From: Eve Hearsey
Sent: 09 March 2012 14:16
To: Planning.Responses
Subject: FW: Personal Objection Re ASDA PLANNING CHANGES - 8 Mar 2012

Please could these be attached to FG/16/12 under Consultation Environmental Health. Thanks

Further to your response to the ASDA application on 2nd March, I have received this letter of objection to the proposal, and as you can see, on the attachment, the objector specifically asks a question on the air conditioning. I would be grateful if you could email your response to his views so that I can incorporate them into my report that I am currently writing.

Proposed Roof Plan

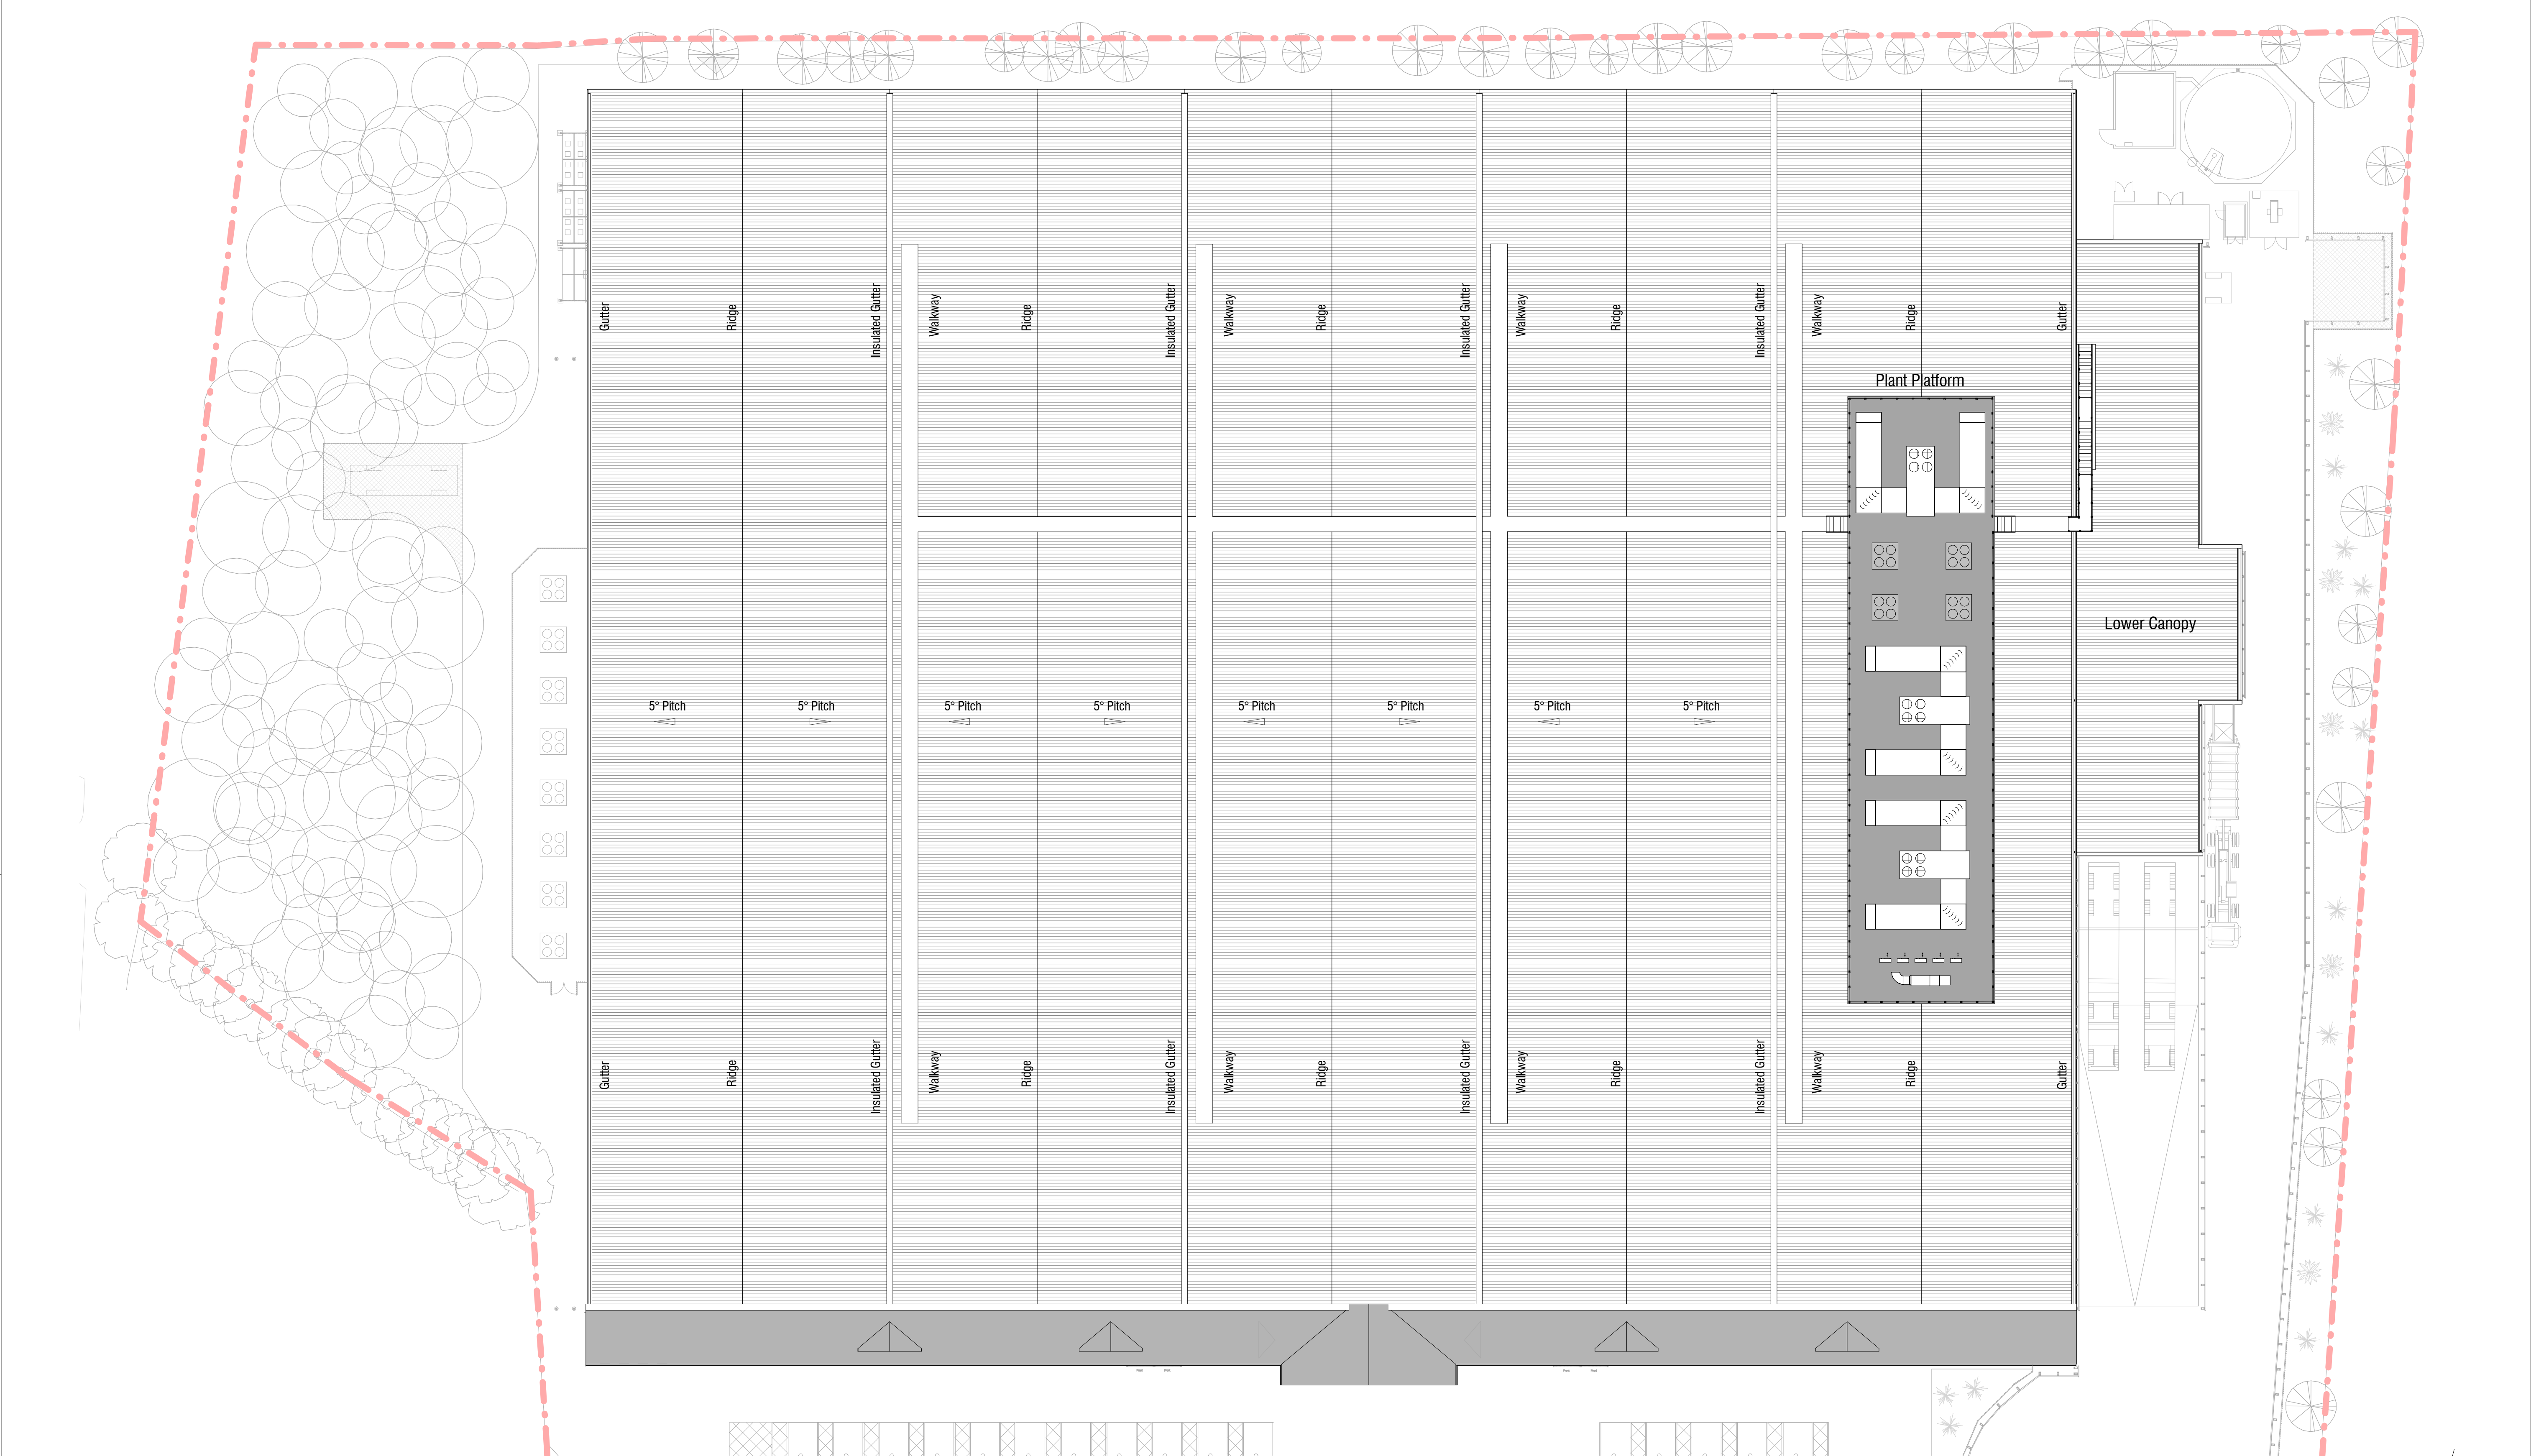
Further to our conversation I can confirm that I am unable to comment without details of noise produced by the plant, ideally a noise consultants report should be obtained to ascertain the impact of noise produced by the plant on existing background noise levels at existing and potential future noise sensitive development. It is likely that significant impact may be mitigated by selection of quiet plant and provision of acoustic screening or enclosures if appropriate.

Furthermore, your earlier comments talked about possible future residential development which may be closer the the AC units. There is an adjoining site (Jenkins Yard) which abuts the ASDA site for 39 dwellings. It has been allowed on appeal, but Arun are challenging the decision.

If Arun were to loose the challenge and the dwellings got approval, what measures would need to be put in place to prevent a noise nuisance on those properties?
